P25-009\_KirkleesCouncil\_20012025\_LetterofObjection\_ReplacementDwelling\_Brayside\_71CoachRoad\_HD22NW

**RE: 2024/62/93359/W – DEMOLITION OF EXISTING DWELLING AND GARAGE AND ERECTION OF DETACHED DWELLING WITH DETACHED GARAGE - BRAYSIDE, 71 COACH ROAD, COWCLIFFE, HUDDERSFIELD, HD2 2NW – MR AND MRS HOLLINGDRAKE**

north elevation

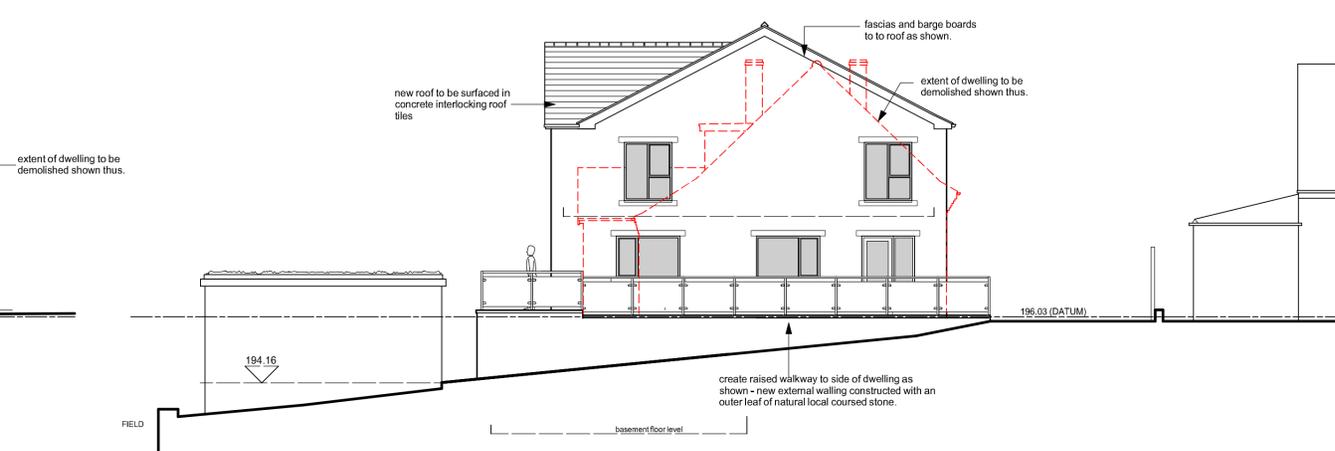
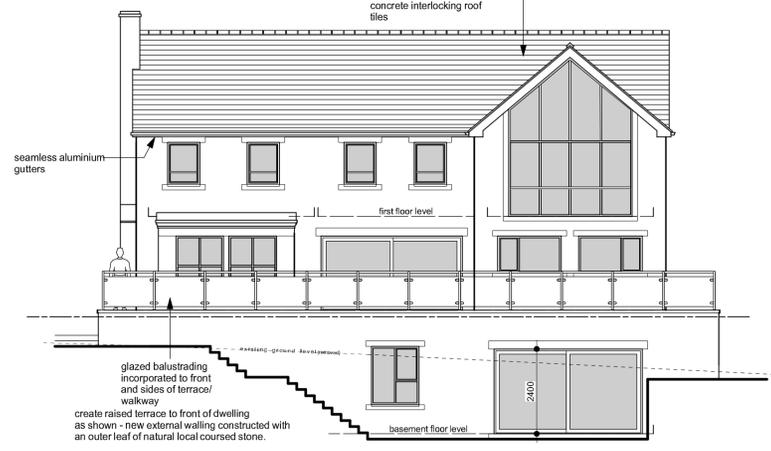
The applicant's application submission confirms that the proposed northern elevation of the dwelling, which would be directly due south of the southern elevation of my client's property, will be both taller and wider than the existing dwelling it would replace.

The neighbouring dwelling at 9 Fixby Park Drive has a ground floor conservatory / lounge window in its southern elevation which is just 1.4 metres from the boundary and aspects directly due south towards the proposed replacement dwelling. Nonetheless, no detailed assessment has been carried out by the applicants to demonstrate that the proposed development will not impact adversely on the daylight available to habitable rooms in the south elevation of the dwelling at 9 Fixby Park Drive.

Given the proximity of the proposed development to neighbouring properties and its scale, form and orientation, it is vital that we ensure that the application proposals will not reduce unacceptably available daylight to openings to habitable rooms or have an overbearing impact on neighbouring properties.

site plan 1-200

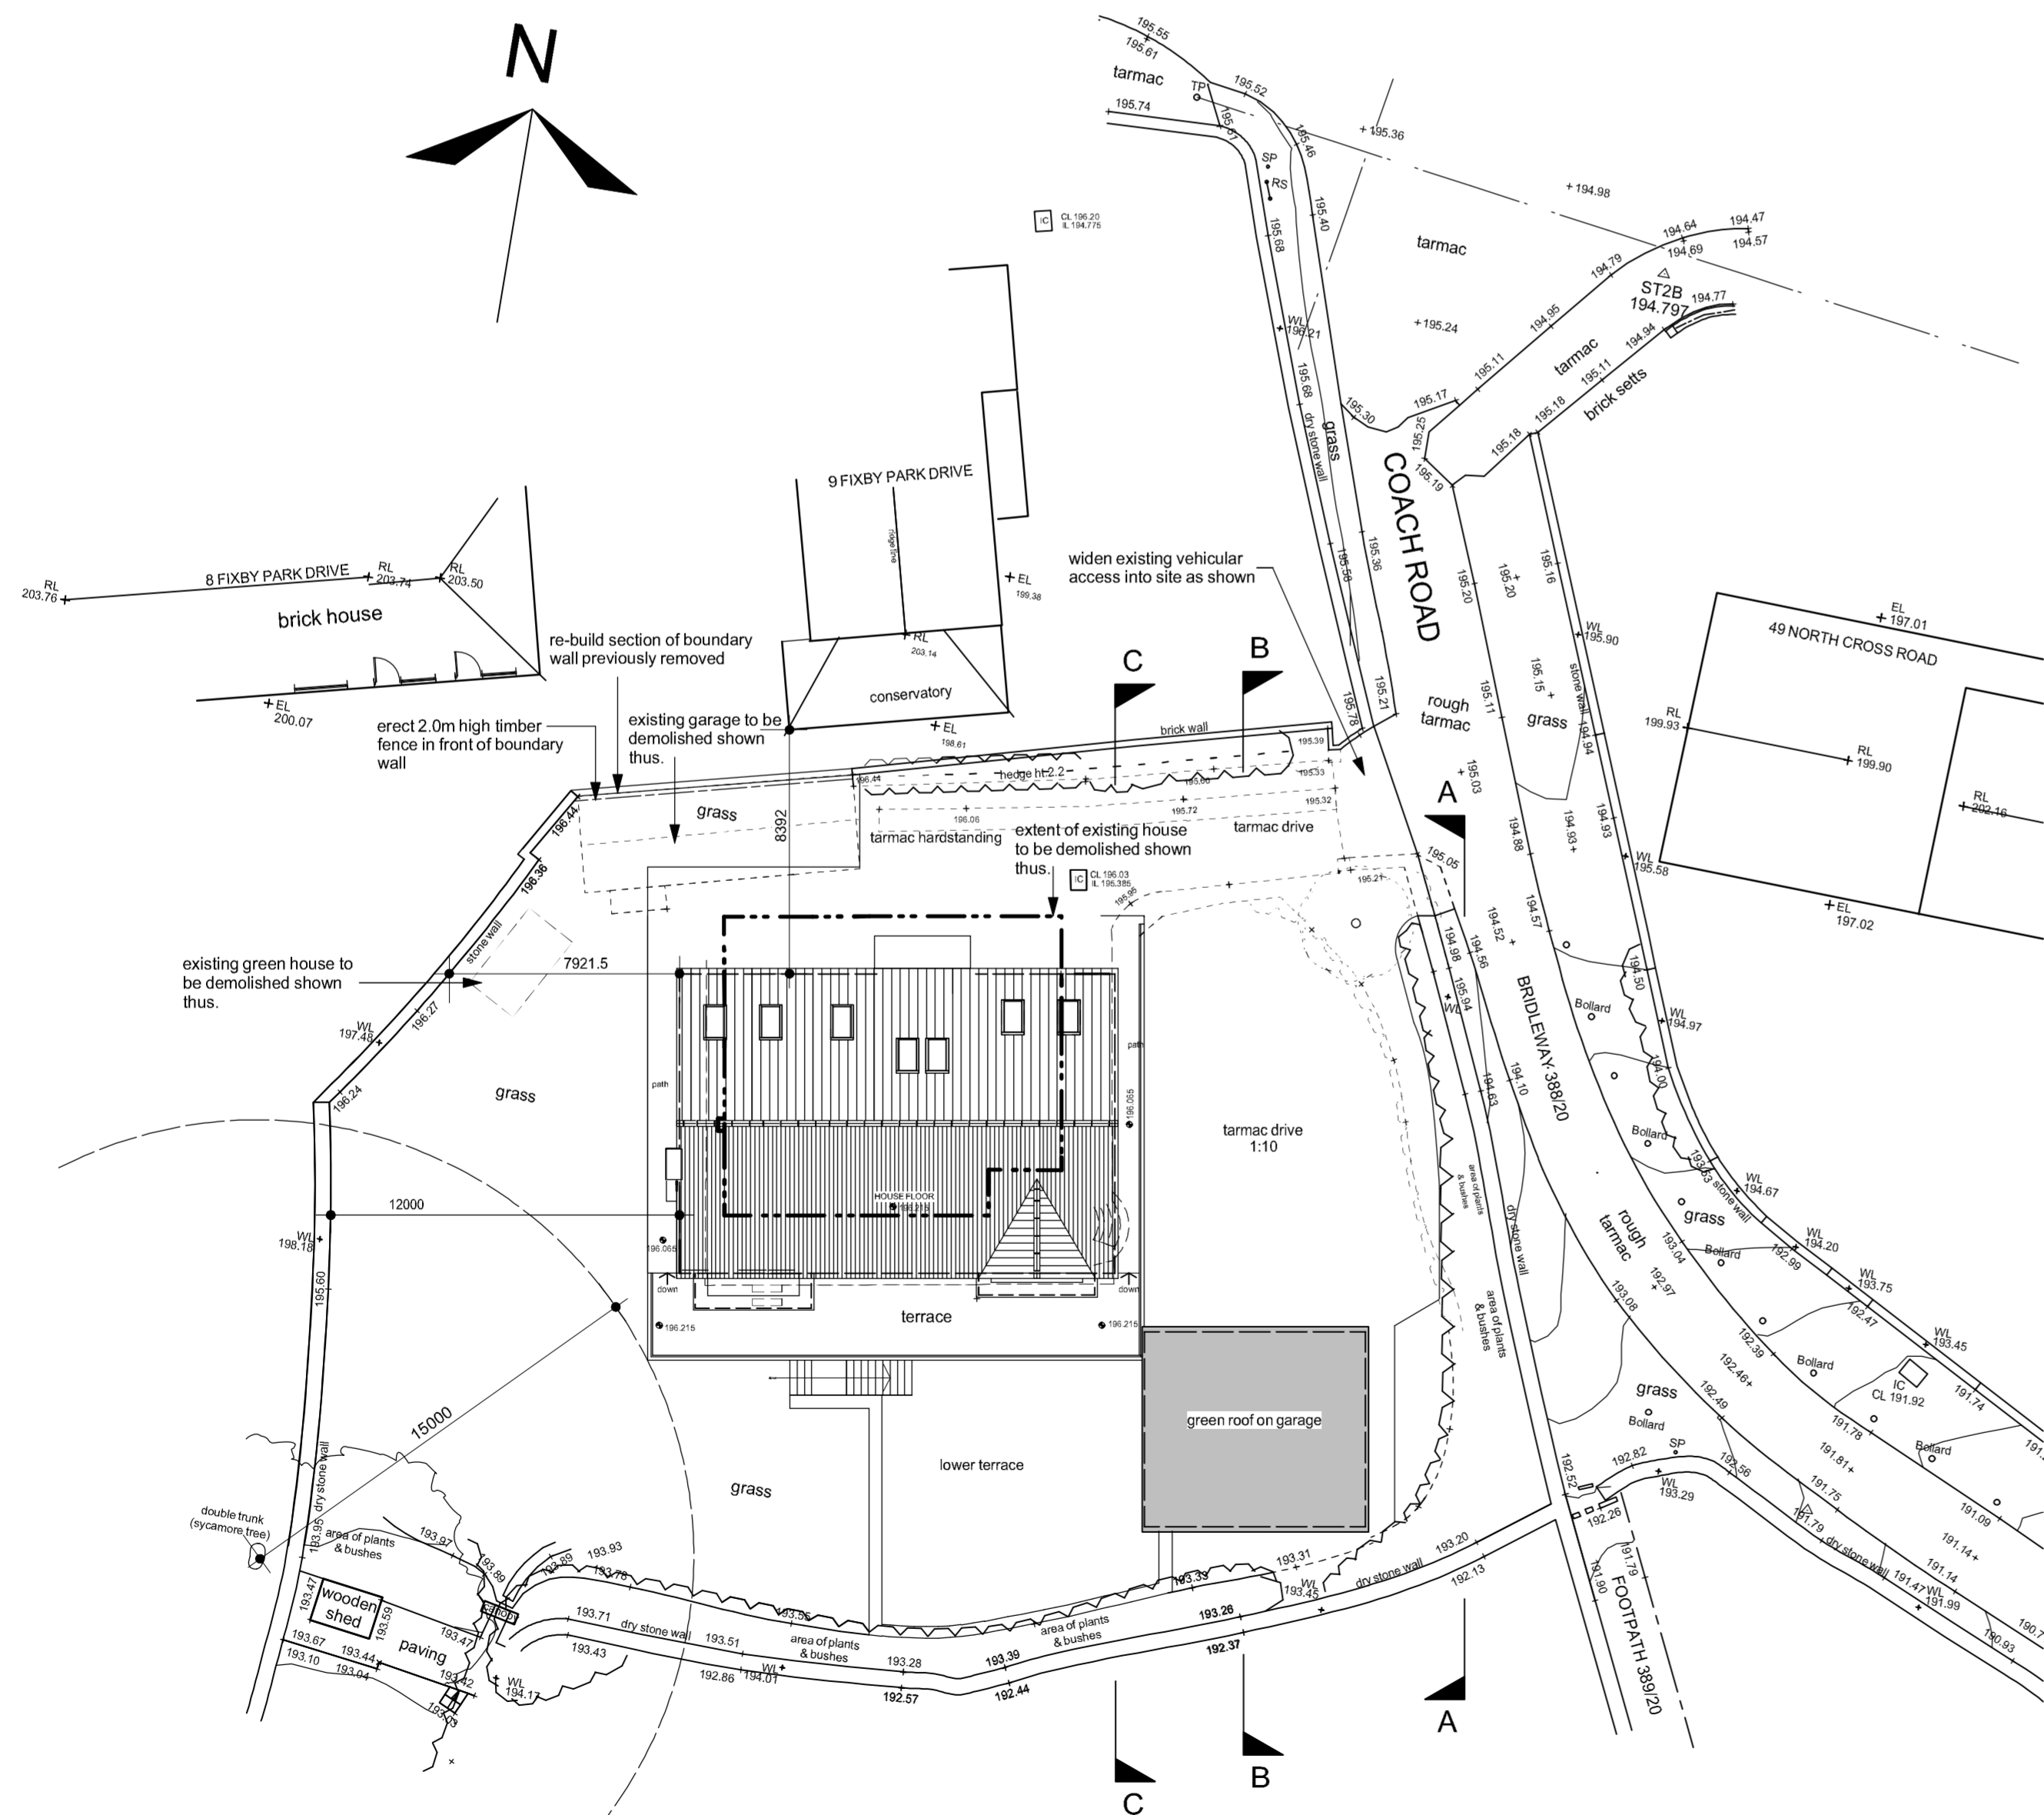
The submitted plans also suggest that boundary fencing of even height will be erected around most of the common boundaries between these neighbours regardless of the impact that these would have on the outlook presently enjoyed by residents or on the character and appearance of the area. Presently common boundaries between properties, particularly between buildings and the road frontage are defined by low walling and garden planting rather than tall fences.
